**PLANNING REPORT #15-05**

**IRIS PARK APARTMENTS  
VICINITY OF 189-201 PARK AVENUE  
SUBDIVISION AND SITE PLAN REVIEW  
IRIS NETWORK, APPLICANT**

Submitted to:  
Portland Planning Board  
Portland, Maine

March 4, 2005

STORMDRAIN PLAN AROUND KING MIDDLE SCHOOL
 SCALE: 1"=20'

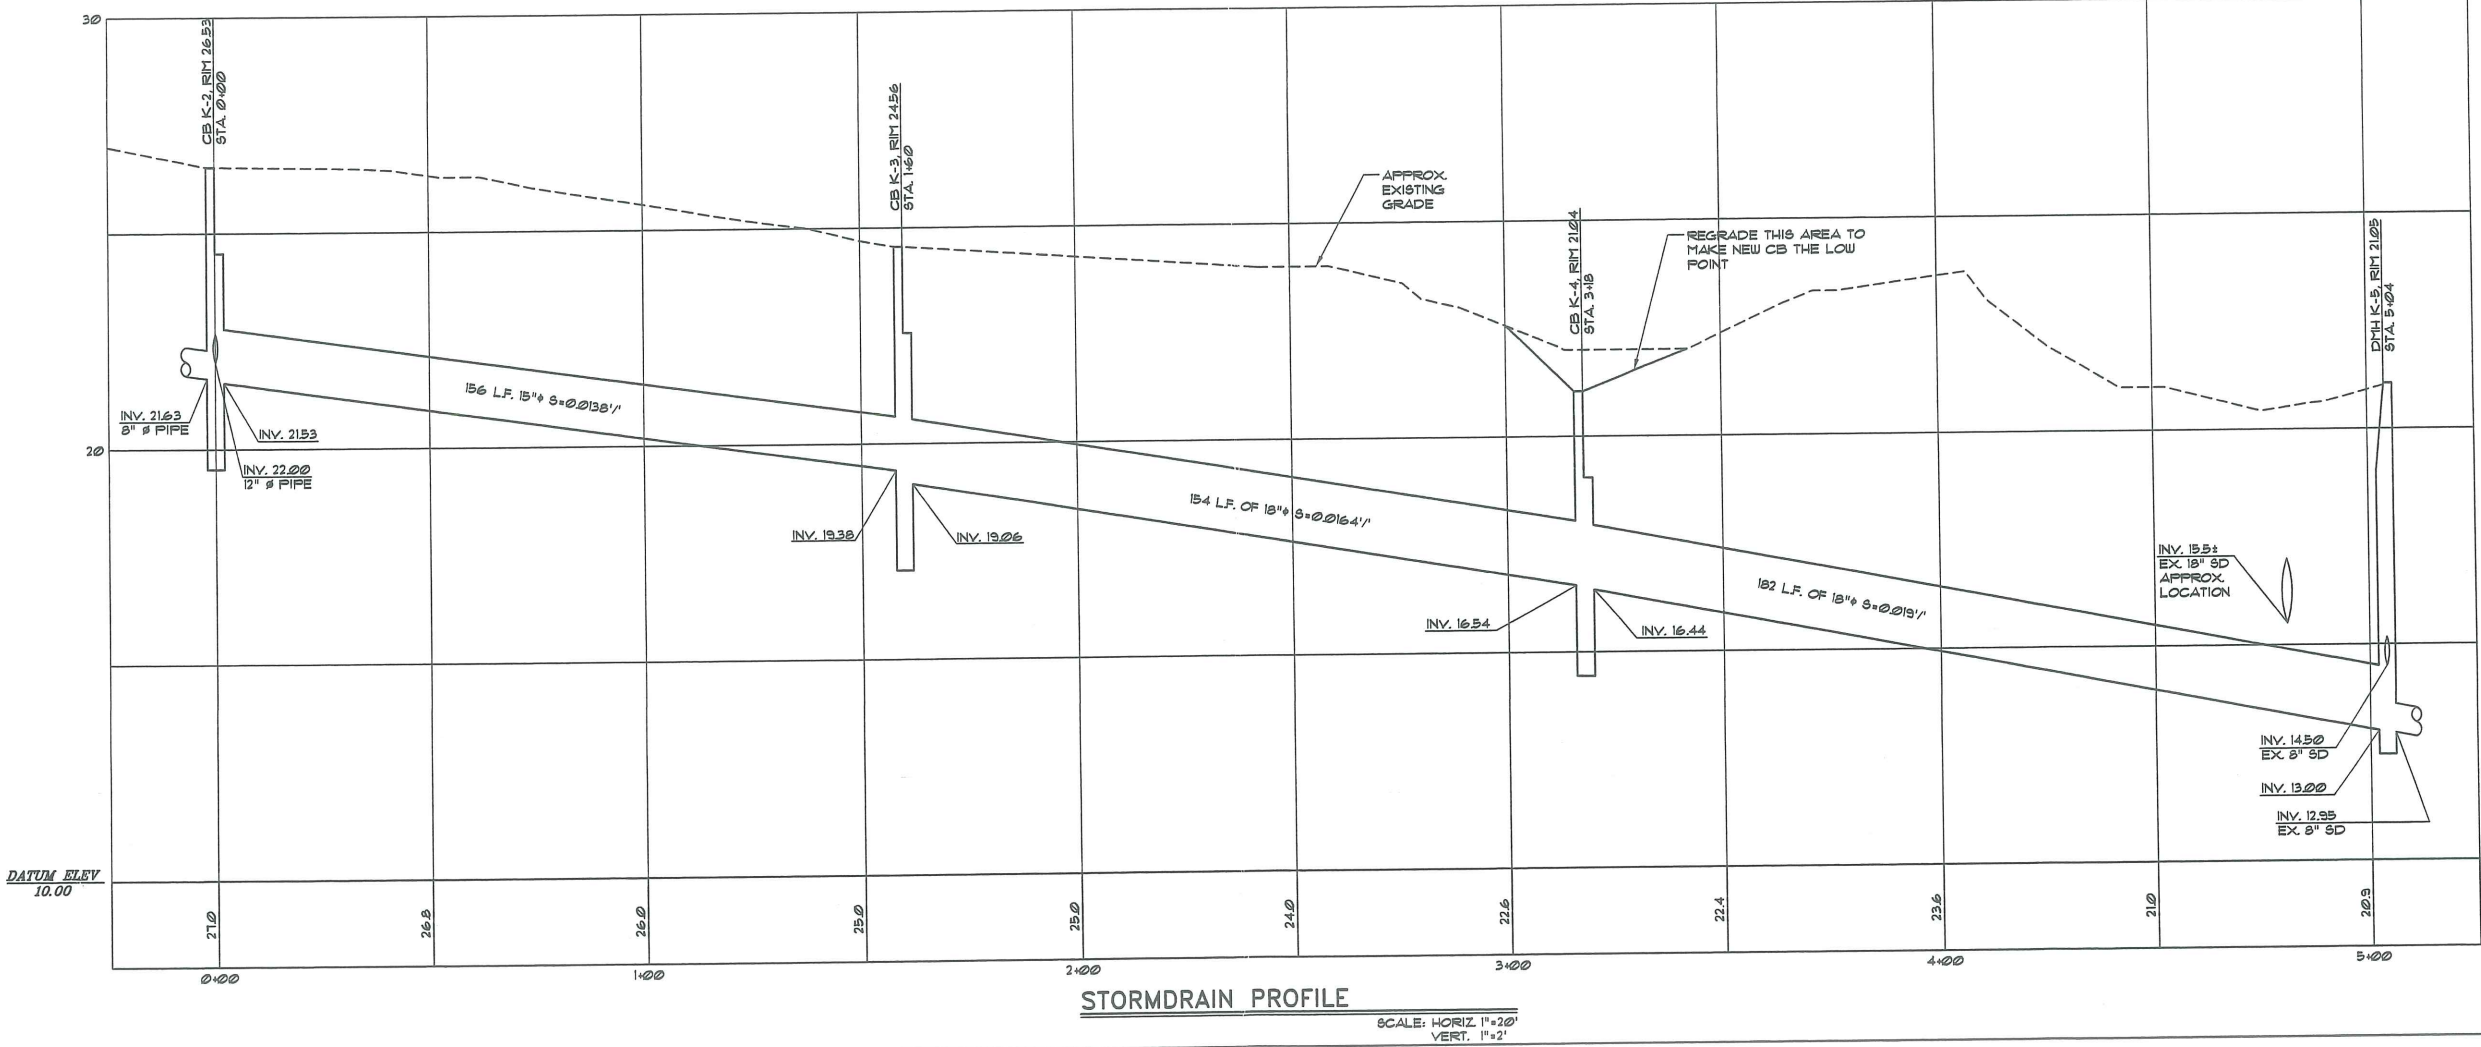
The applicant has designed offsite pipe upgrades to the overall school/city system. Public Works and the DRC believe it to be in the City's best interest to proceed with the applicant's offer. The applicant has provided plans with a new layout, pipe lengths, invert elevations, and pipe sizes able to handle the entire upgrade as noted in the stormwater report. However, the eventual discharge point near Deering Avenue is restricted by the outlet of the last catch basin which has only an eight inch pipe crossing Deering Avenue. Therefore, the pipe proposed will back up and surcharge.

In large storms the surcharge will overflow the last connected basin and then by surface flow reach another catch basin on school ground that leads to another separate storm drain collecting the front loop access of King Middle School. The surcharge depending on the storm event could also back up in one other basin along the new storm drain layout. Based on discussions between Public Works and the DRC, they feel that an overflow pipe from the last basin at the King Middle School entrance basin should be installed as high as possible to alleviate overtopping and reduce potential for surface flooding. These two separate storm drain lines in fact discharge to the same eventual combined sewer, but they are of different size and take different course to the same point.

The City is requesting that the applicant inspect and camera the last 8-inch pipe length that crosses Deering Avenue to assure the pipe is in operable condition without obstructions or breaks. Calculations estimating the actual flow to both pipes in the 2 and 25-year storms will be required to approximately size future replacement downstream pipes in Deering Avenue.

- that the applicant revise the plans to reflect the DRC's comments in the memo dated March 3, 2005 in regards to drainage and other detail issues.

DRAWING:
GRADING AND UTILITIES PLAN
 SCALE: AS SHOWN
 DATE: JAN. 13, 2005

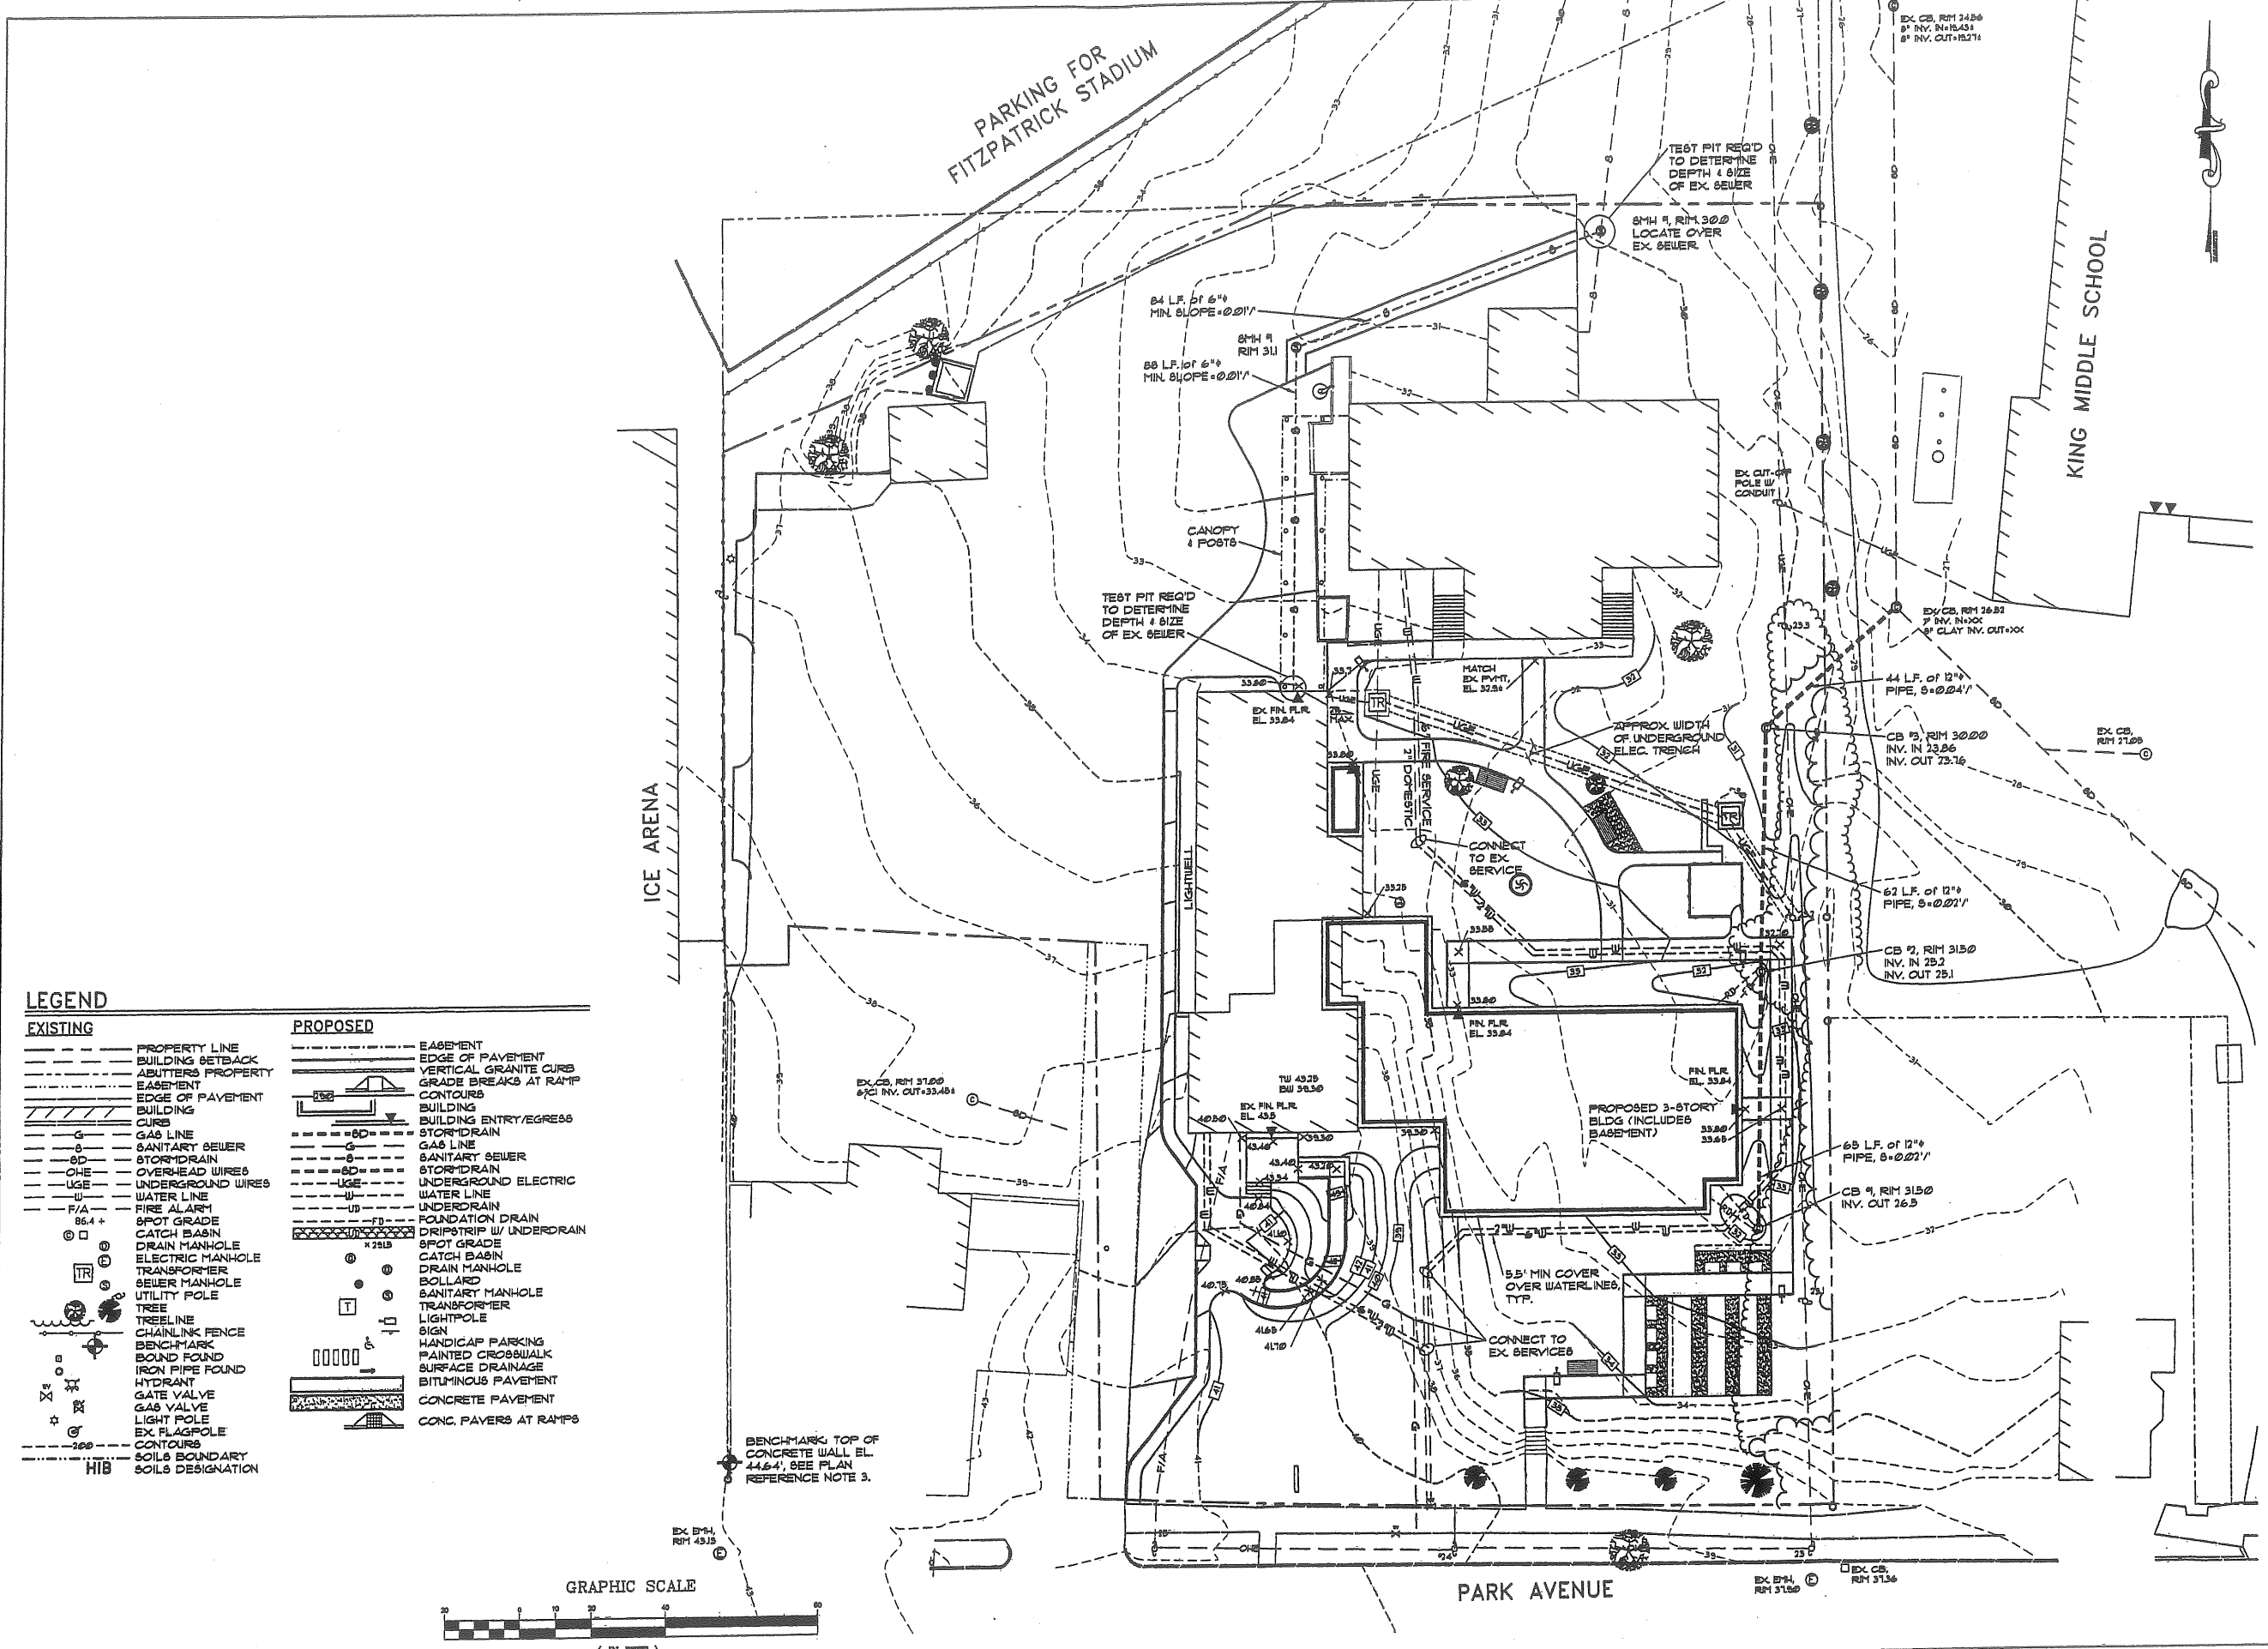
The Traffic Engineer has reviewed the plans and is recommending that the driveway alignment be modified. The modification will eliminate the lane shift entering and exiting the site and provide greater separation between the Iris Network site and the Exxon Service Station. The change will require the shifting of the easternmost curb by approximately 10 feet and will also require the extension of the curb area/sidewalk in front of the Exxon Station to be shifted by approximately 10 feet. The Traffic Engineer's memo is included as Attachment 12. A potential condition of approval is:

The stormwater calculations imply an addition of peak rate of runoff. The applicant has shown that they can meet or nearly meet the runoff rate in the post condition in the 2, 10 and 25-year storms for two study points, however the calculations show a substantial increase in all storms for the third study area. There appears to be a lengthy run of stormwater runoff extending from the rear of the gas station to the rear northern corner of the parking area. The DRC and Public Works is recommending that a catch basin be installed near the new sewer service crossing and tie it into the storm drain line heading northerly on the King Middle School lot. This will collect and reduce shallow flows on the pavement, and extend the pavements lifecycle and improve safety.

And lastly, it shall be the applicant's responsibility to assure that no additional wyes or connections to the abandoned storm drain are blocked, or left without outlets, thereby causing flooding or backwater problems. A potential condition of approval is:

- that the plans be revised to modify the driveway alignment based on the Traffic Engineer's memo dated March 3, 2005, to be reviewed and approved by the Traffic Engineer.

DRAWING:
PRELIMINARY PLANTING PLAN

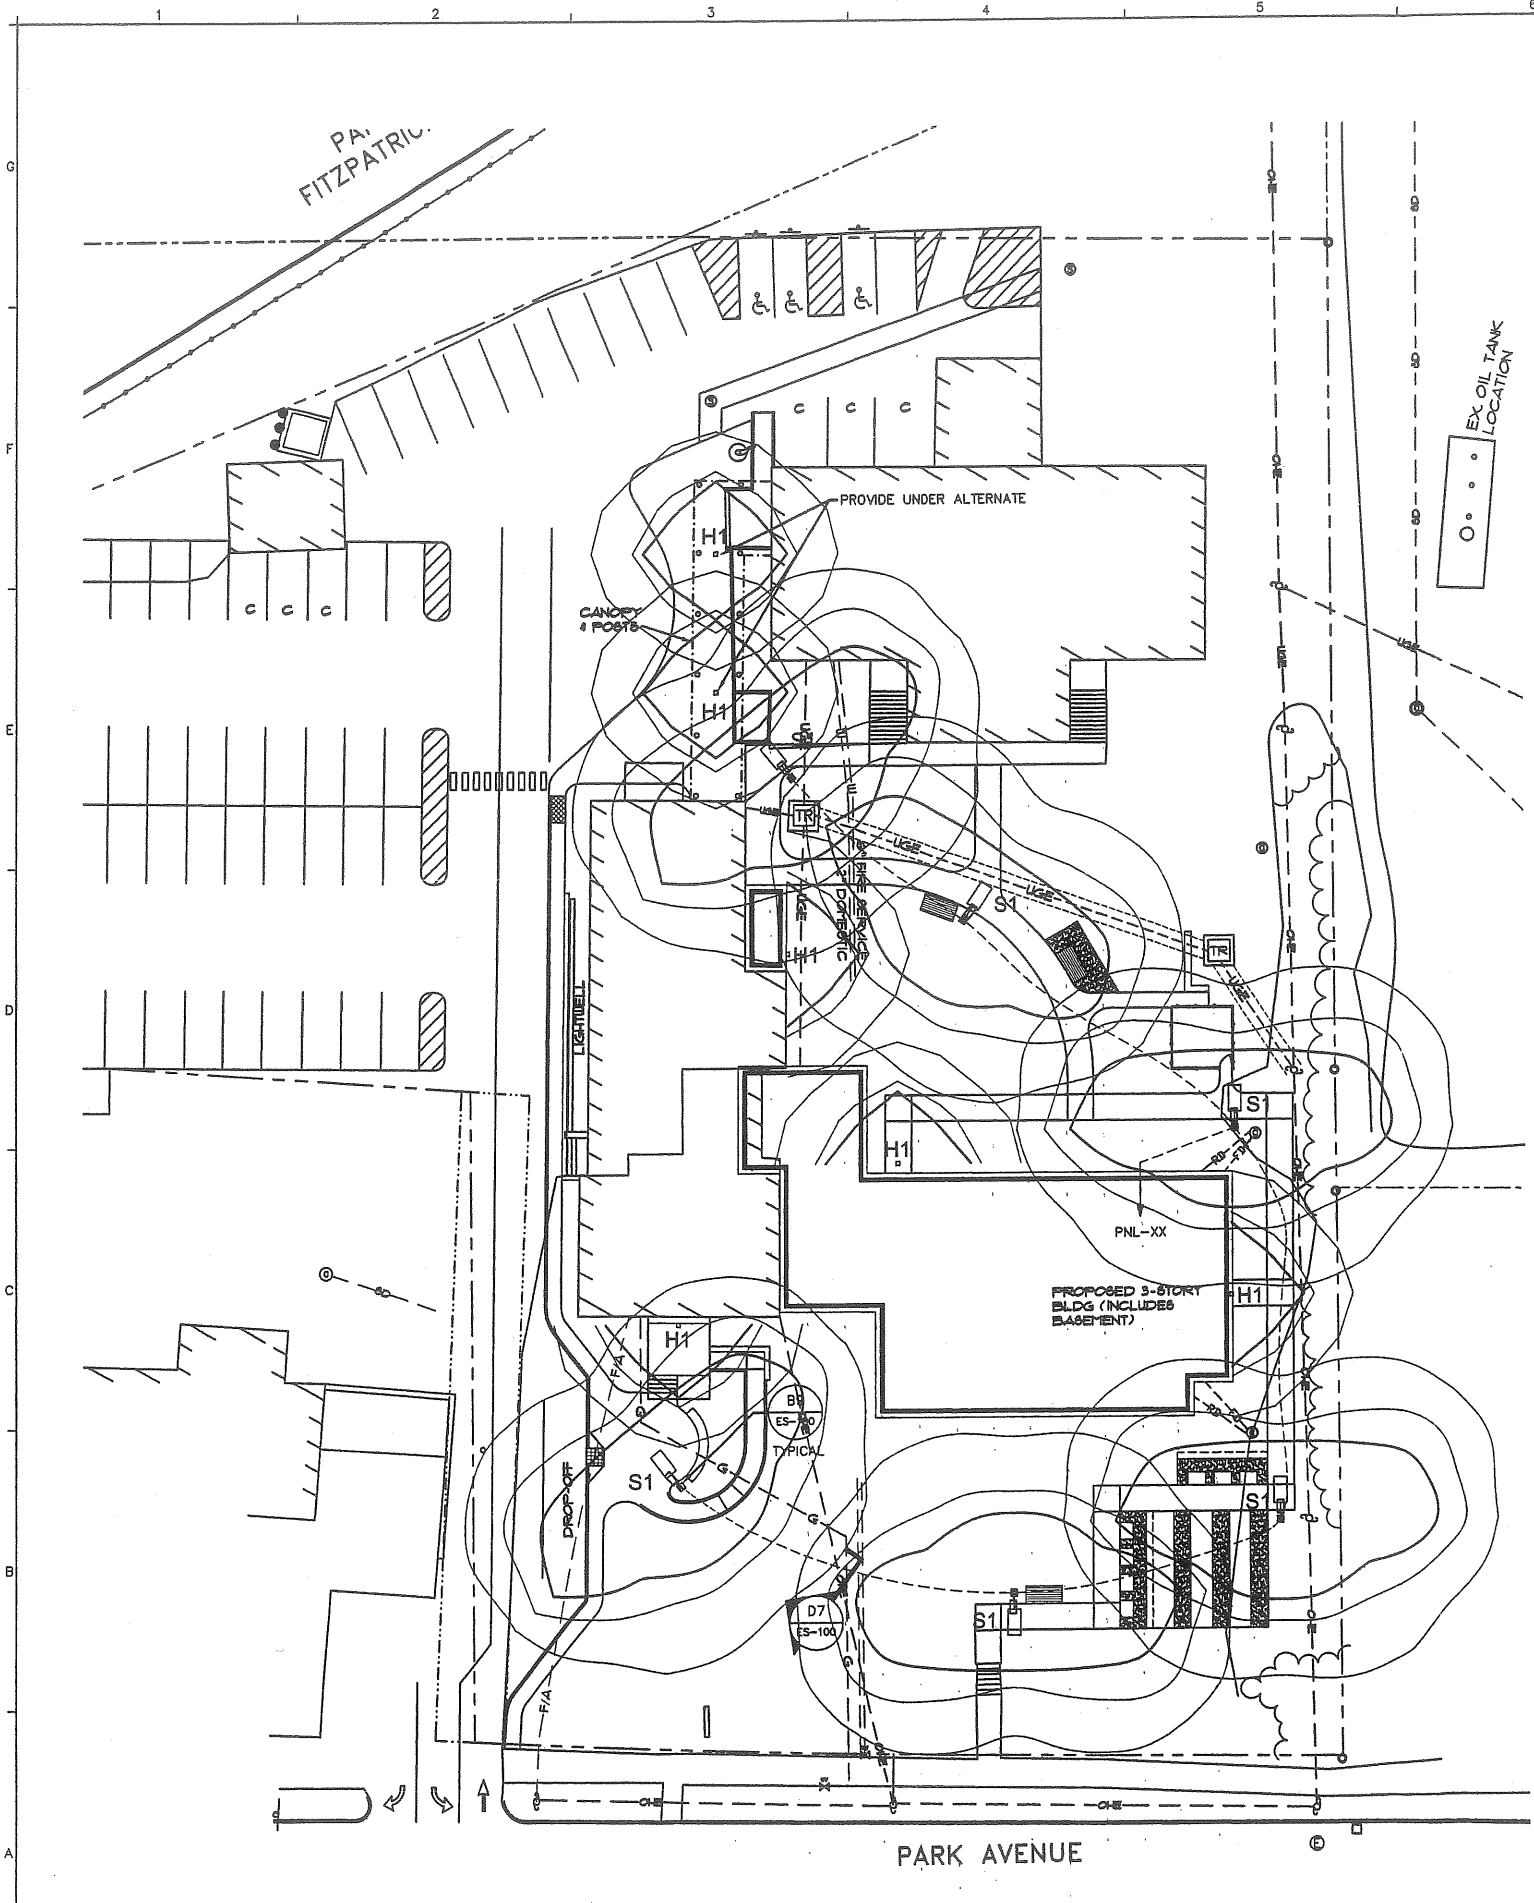
The subdivision ordinance states that with a residential development, two trees per unit shall be required. The applicant is proposing to keep twelve (12) of the existing trees that are on-site currently and are proposing thirty-one (31) new trees for a total of forty-three (43) trees. The subdivision ordinance requires sixty-two (62) trees for the site.

The City Arborist has reviewed the plans and is recommending that the applicant replace the existing Catalpa tree proposed to be removed, with a 2.5" caliper Catalpa tree. The City Arborist is also recommending that the applicant provide additional landscaping along the front of the Barker Building expansion. The applicant may also be able to provide additional trees at the rear of the existing Ryan Building and around the parking area. A potential condition of approval is:

- that the applicant revise the landscaping plan to provide additional trees to meet the subdivision ordinance and replace the existing Catalpa tree with a 2.5" caliper Catalpa tree, to be reviewed and approved by the City Arborist.
